**Case Officer:** Tom Webster

**Applicant:** Firethorn Developments Limited

**Proposal:** Discharge of Condition 11 (phasing plan) of 21/01630/OUT  
(APP/C3105/W/23/3315849)

Phasing Plan

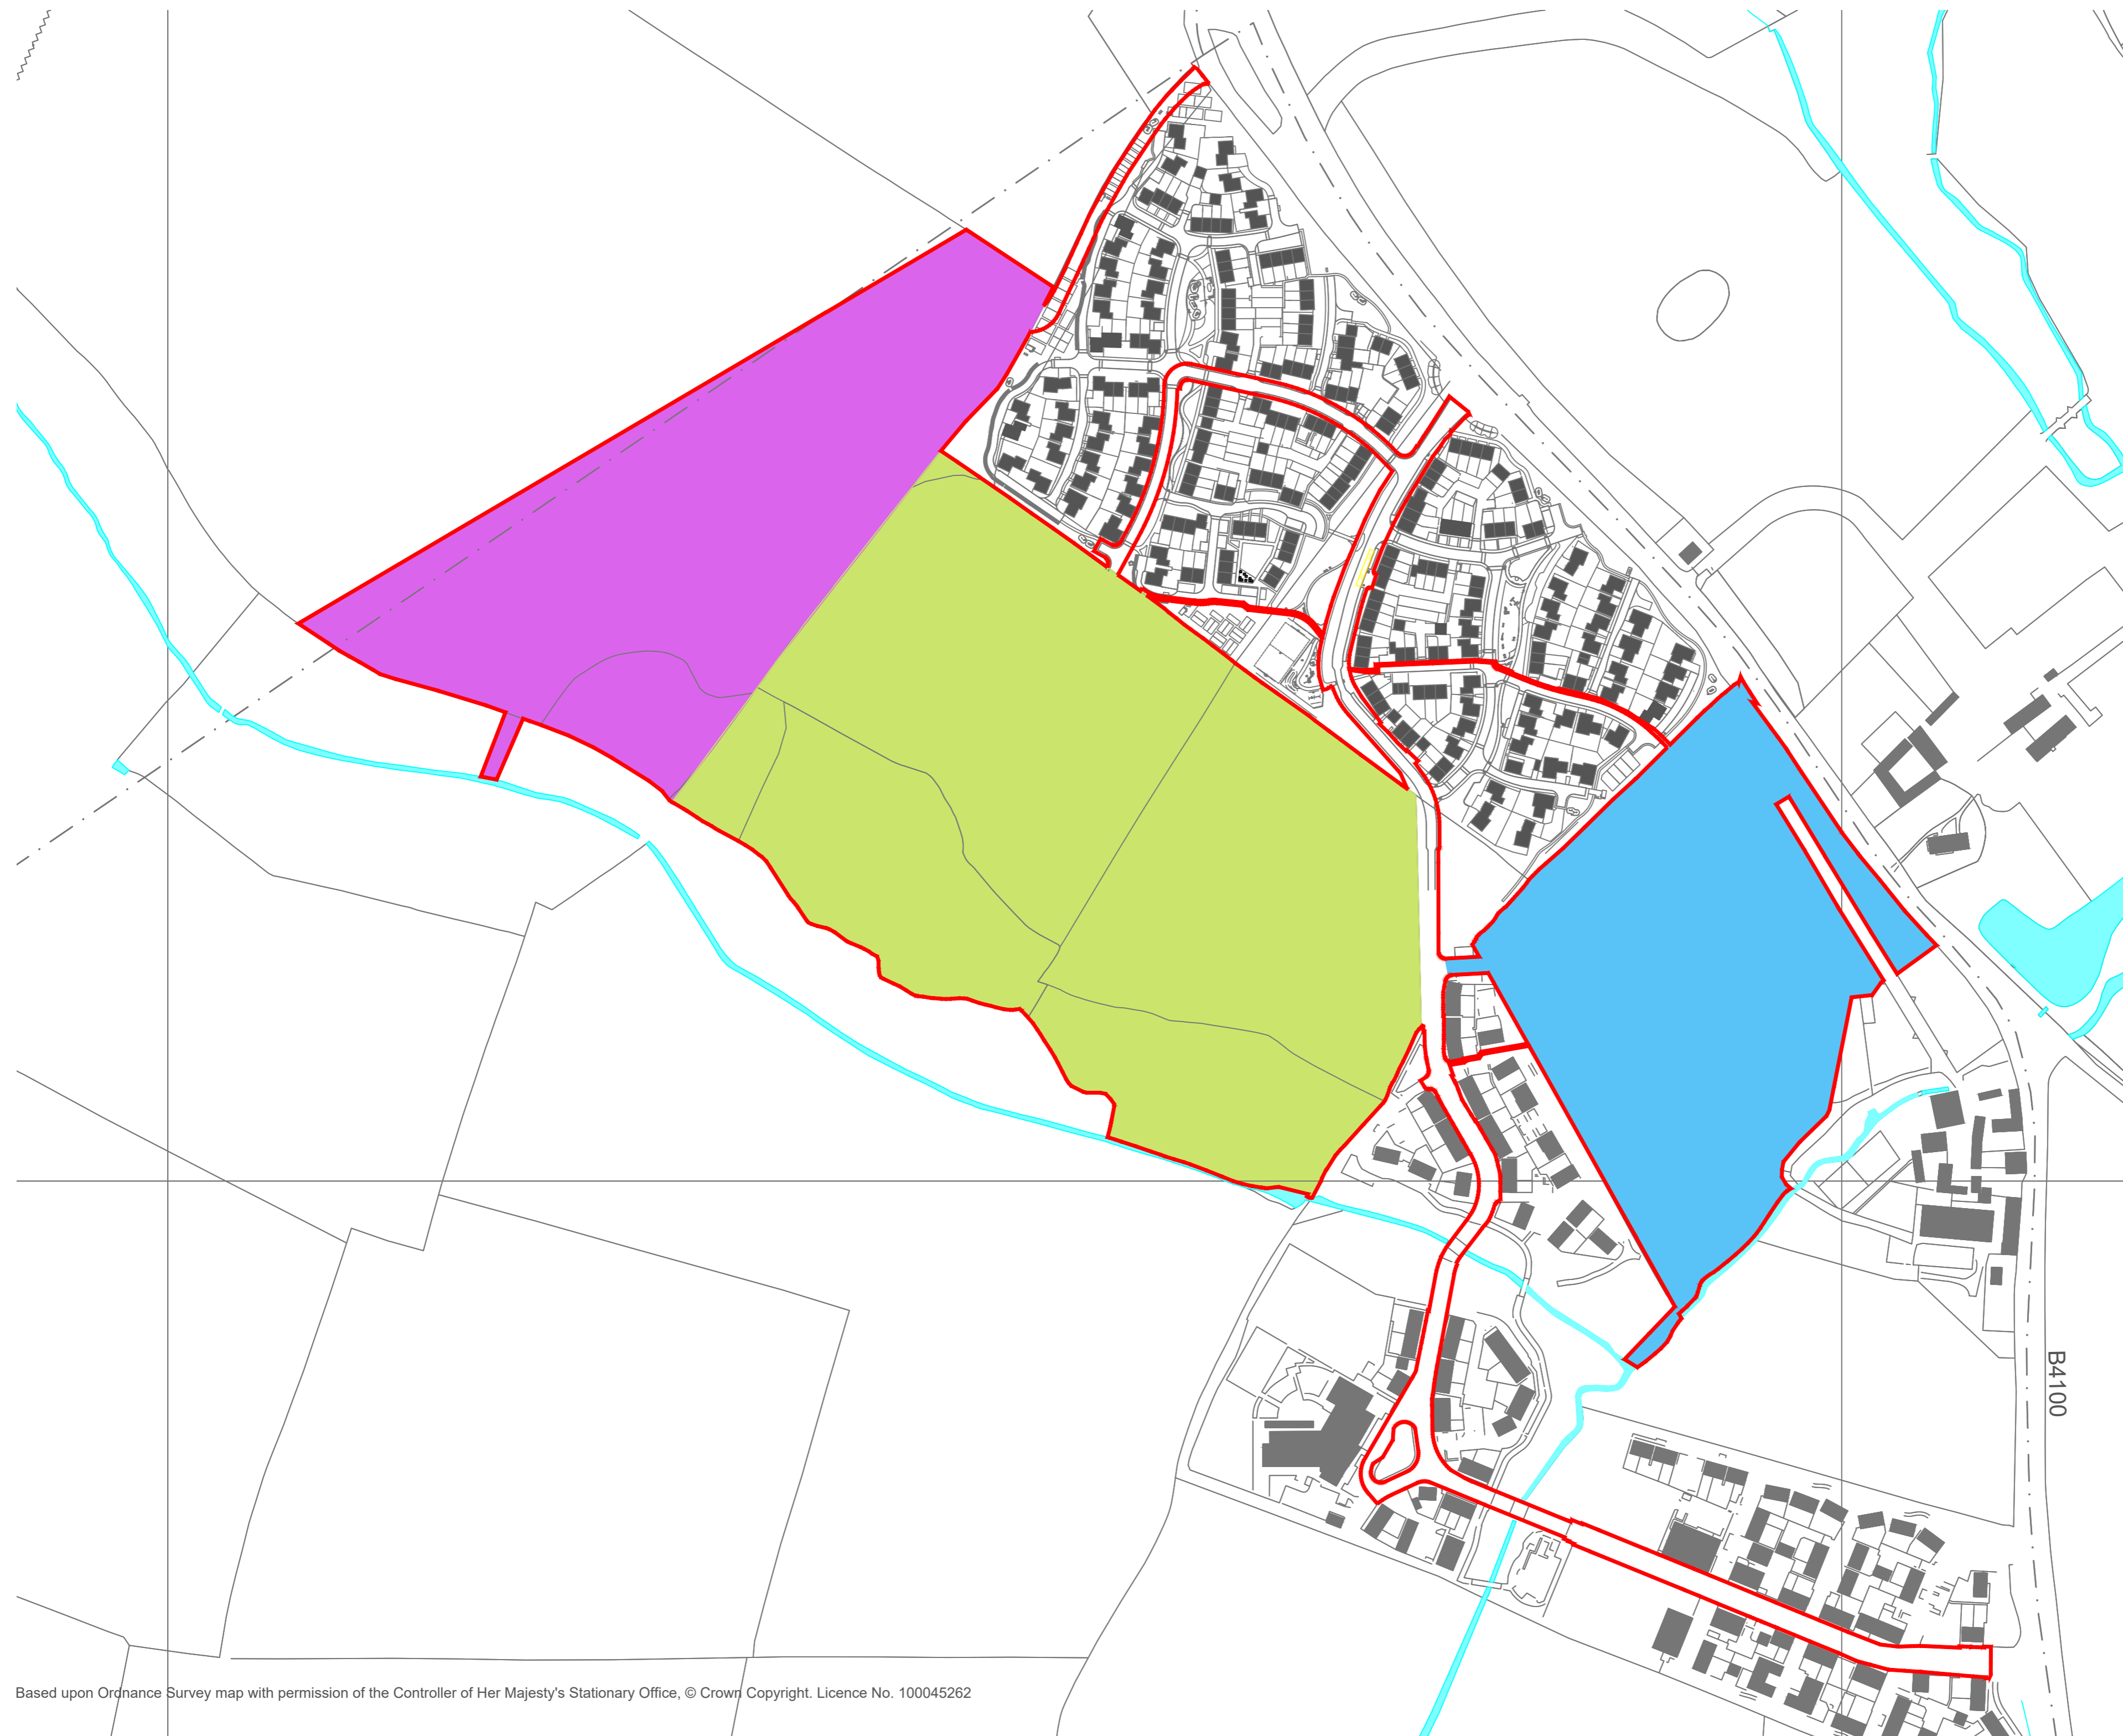
*“The phasing plan does not include the full red line area. This is particularly relevant as it doesn't include the northern part of the site adjoining the layby, where the construction access will be built. The plan also doesn't indicate the order in which the phases will be developed.*

*“If the planning authority is content with the infrastructure (including construction access haul route) not being shown as a phase, then I can remove my objection because this does at least now show the application boundary including the haul route. “*

*“Infrastructure is not shown separately. However, highways triggers relating to construction and permanent accesses are set out in conditions/obligations, therefore the lack of detail on the phasing plan is not, I believe, an issue for highways.*

However, subsequently a revised phasing plan was submitted which shows a), the sequence of phases (the parcels of land in number order); and

b) an amended red line to encompass the northern part of the site adjoining the layby

The Highways Authority had raised an objection, but, following amendments to the phasing plan, have now withdrawn their objection. The phasing plan now has a sequence of parcels (1,2 & 3), in line with the wording of condition 11. It also

incorporates the northern part of the site adjoining the layby, as requested by the Highways Authority.

Given the above, the revised phasing plan 021 Revision D is considered to be acceptable, and Condition 11 can be discharged.
